Denim Days Festival

Fire Marshal Division

**Re: Erwin Denim Days  
100 North 13<sup>th</sup> St.  
Erwin, NC 28339**

**Application Number – FMFW1808-0008**

MAP 1

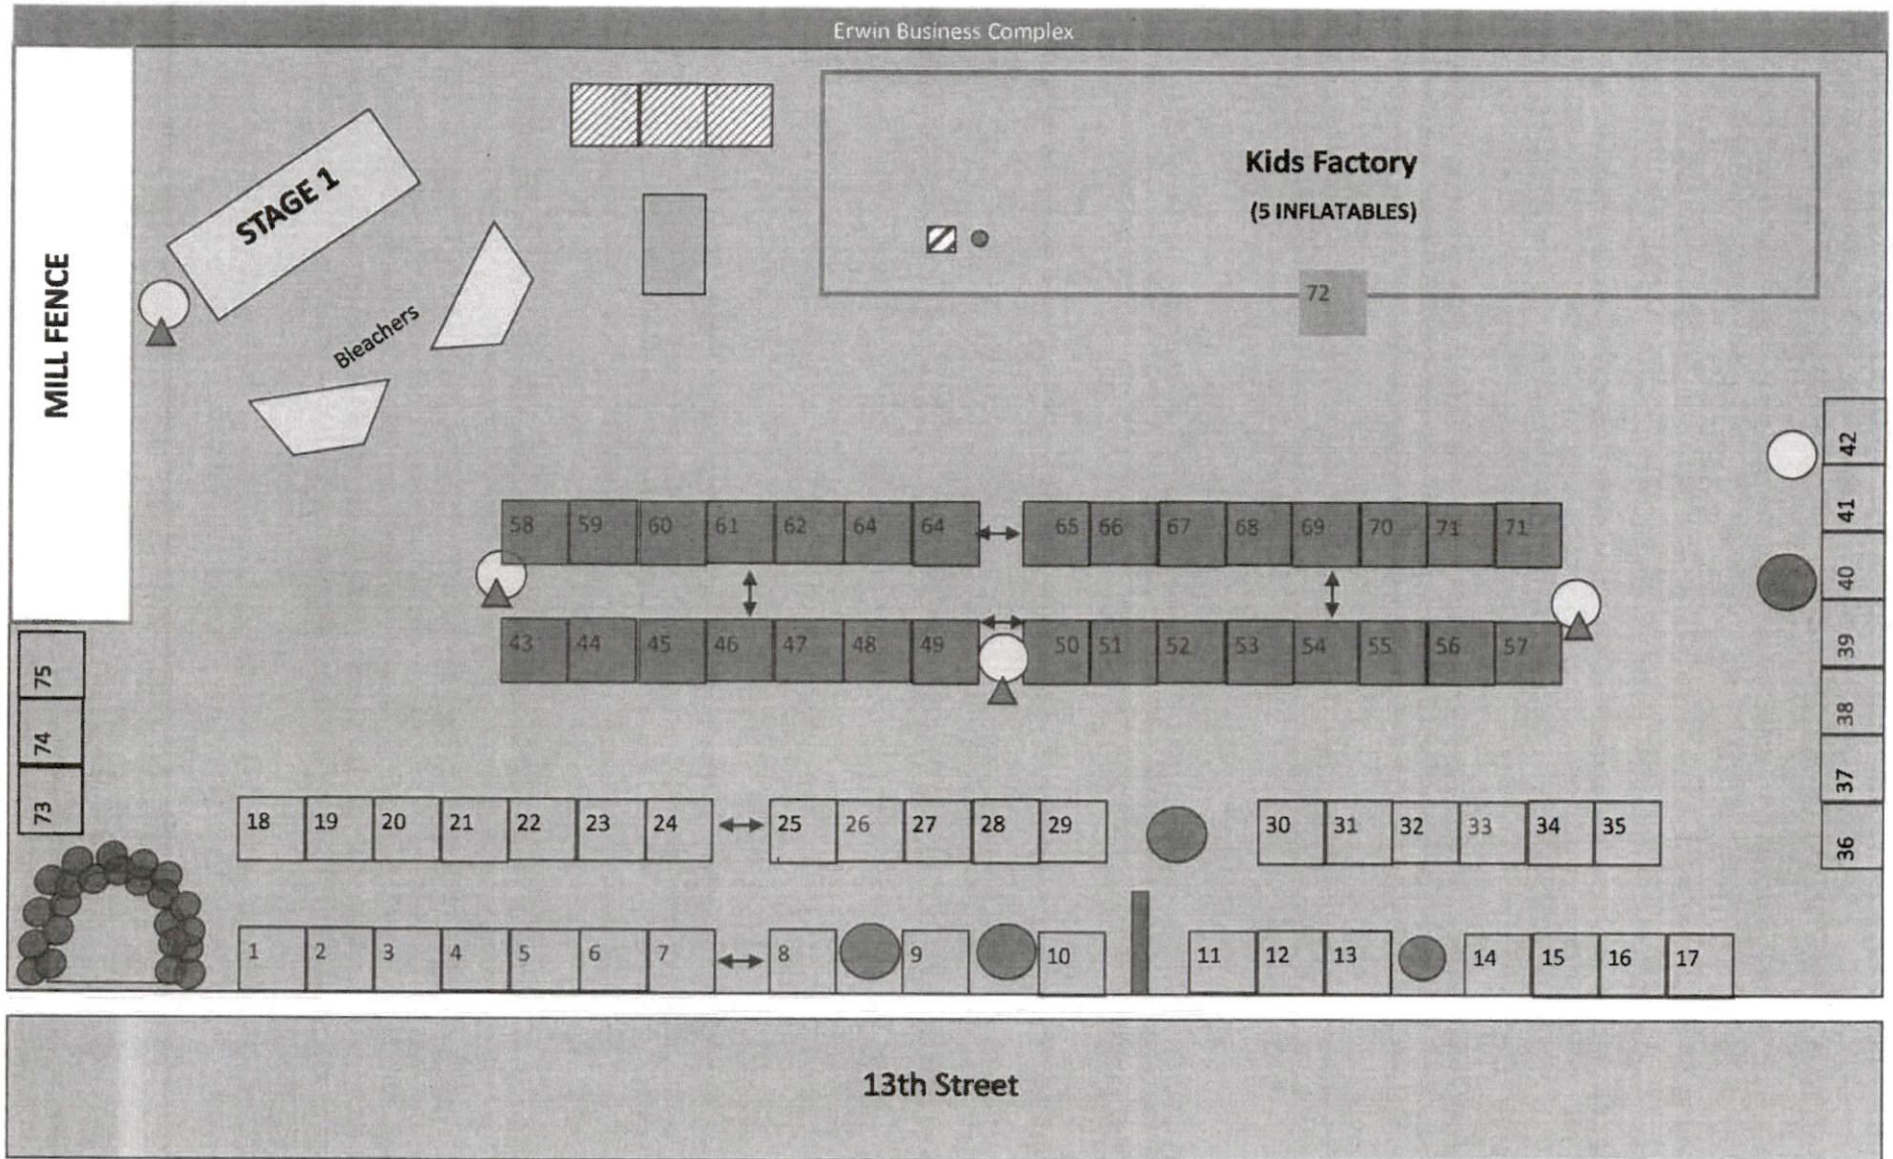
- A permit will be issued for the special assembly that will include the event as a whole.
- A permit may be issued for other tent areas if the individual tent exceeds 700 ft<sup>2</sup> or the aggregate area of multiple canopies placed side by side without a fire break clearance of 12'

- Portable fire extinguishers shall be provided within a 30-foot (9144 mm) travel distance of commercial-type cooking equipment. Cooking equipment involving vegetable or animal oils and fats shall be protected by a Class K rated portable extinguisher.
- 2A-10B:C fire extinguisher shall be placed at tents/canopies with a travel distance not to exceed 100' from any fire extinguisher

- **2411.6 Outdoor cooking.**
  - Outdoor cooking that produces sparks or grease-laden vapors shall not be performed within 20 feet (6096 mm) from a tent, air-supported, air-inflated or tensioned membrane structure, temporary membrane structure or canopy
  - Cooking is permitted under flame resistant tents meeting NPFA 701 Flame Propagation Standard with a minimum separation of 20' from lot lines, buildings, parked vehicle, other tents and membrane structures.

- **2411.5 Cooking tents.**
  - Tents where cooking is performed shall be separated from other tents, air-supported, air-inflated or tensioned membrane structures, temporary membrane structures or canopies by a minimum of 20 feet (6096 mm).

- **2415 Generators**
  - Generators and other internal combustion power sources shall be separated from tents, air-supported, air-inflated or tensioned membrane structures, temporary membrane structures or canopies by a minimum of 20 feet (6096 mm) and shall be isolated from contact with the public by fencing, enclosure or other approved means.

- **2413.3 Refueling.**
  - Refueling shall be performed in an approved location not less than 20 feet (6096 mm) from tents, air-supported, air-inflated or tensioned membrane structures, temporary membrane structures or canopies.

- **2406.4 Combustible materials.**
  - Hay, straw, shavings or similar combustible materials shall not be located within any tent or air-supported structure containing an assembly occupancy, except the materials necessary for the daily feeding and care of animals. Sawdust and shavings utilized for a public performance or exhibit shall not be prohibited provided the sawdust and shavings are kept damp. Combustible materials shall not be permitted under stands or seats at any time. The areas within and adjacent to the tent or air-supported structure, shall be maintained clear of all combustible materials or vegetation that could create a fire hazard within 20 feet (6096 mm) from the structure.

Combustible trash shall be removed at least once a day from the structure during the period the structure is occupied by the public.
